SEASHORE AVE., PEAKS ISLAND 85-N-1

R3 RESIDENCE ZONE
APPLICATION FOR PERMIT

Re: Seashore Ave., Peaks Island
cor. Ryefield Street 85-1-1-2

Building permit and certificate of occupancy to construct a one story 16' x 40' frame addition on the left side of existing building at the above named location is not issuable under the Zoning Ordinance in the R-3 Residential Zone because:

Feeny's Mkt.
Seashore Ave
Peaks Island

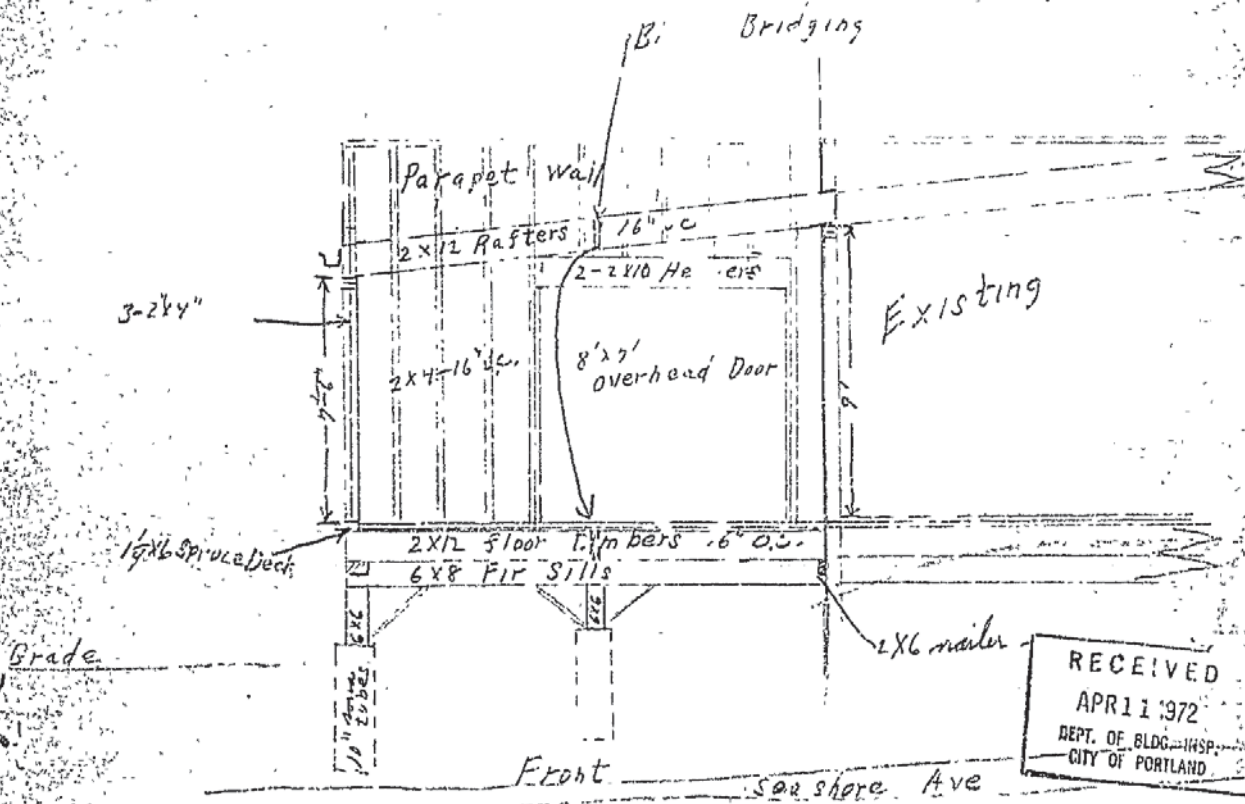
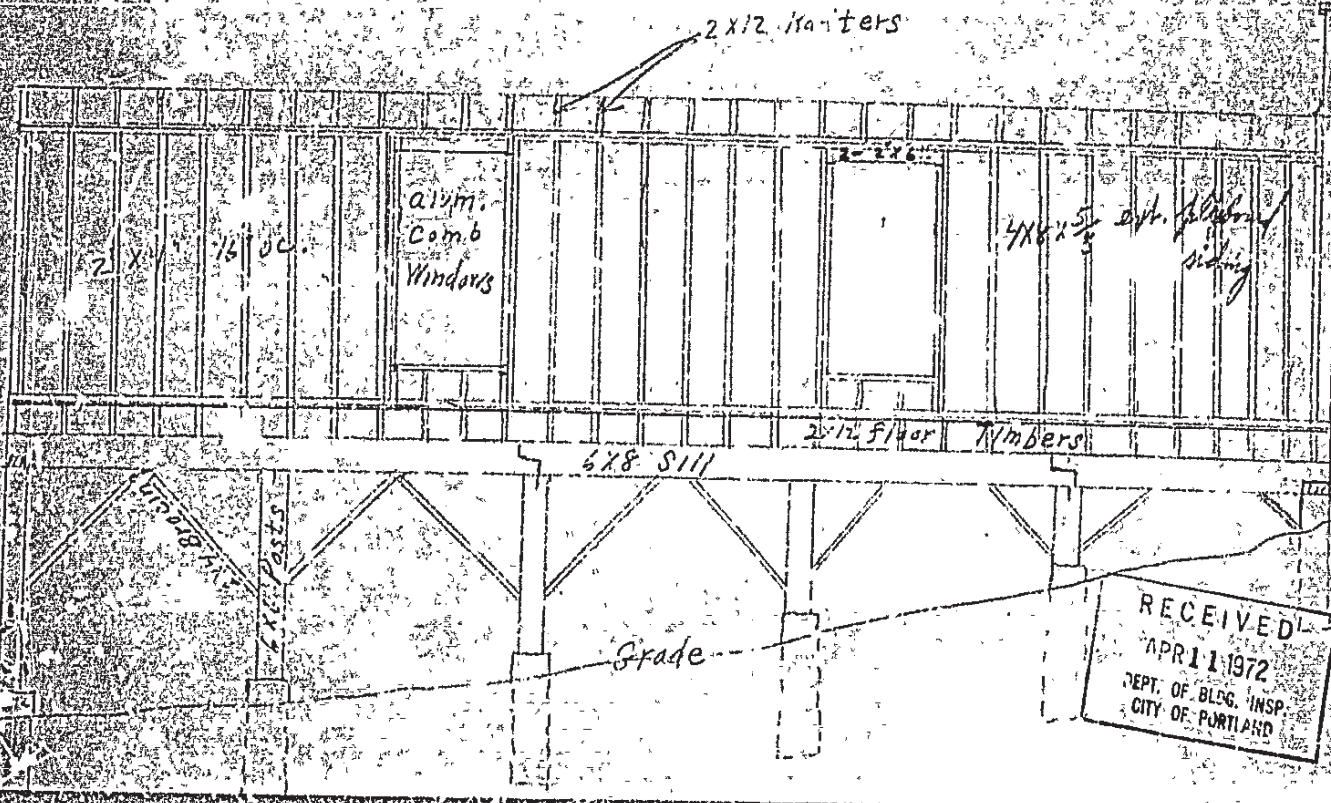
1. The addition would constitute an increase in the existing non-conforming use (retail store) unless authorized by the Board of Appeals under section 602.17.3 of the Ordinance.
2. The front wall of the addition, which an extension of the wall of the existing building, is to be practically on the street line instead of being kept back the 20' front yard distance required for the residential zone by Section 602.19E of the Ordinance.

After public hearing held May 11, 1972, the Board of Appeals finds that all of the above conditions do exist with respect to this property and that a variance should be granted in this case.

It is, therefore, determined that a variance from the provisions of the Zoning Ordinance should be granted in this case.
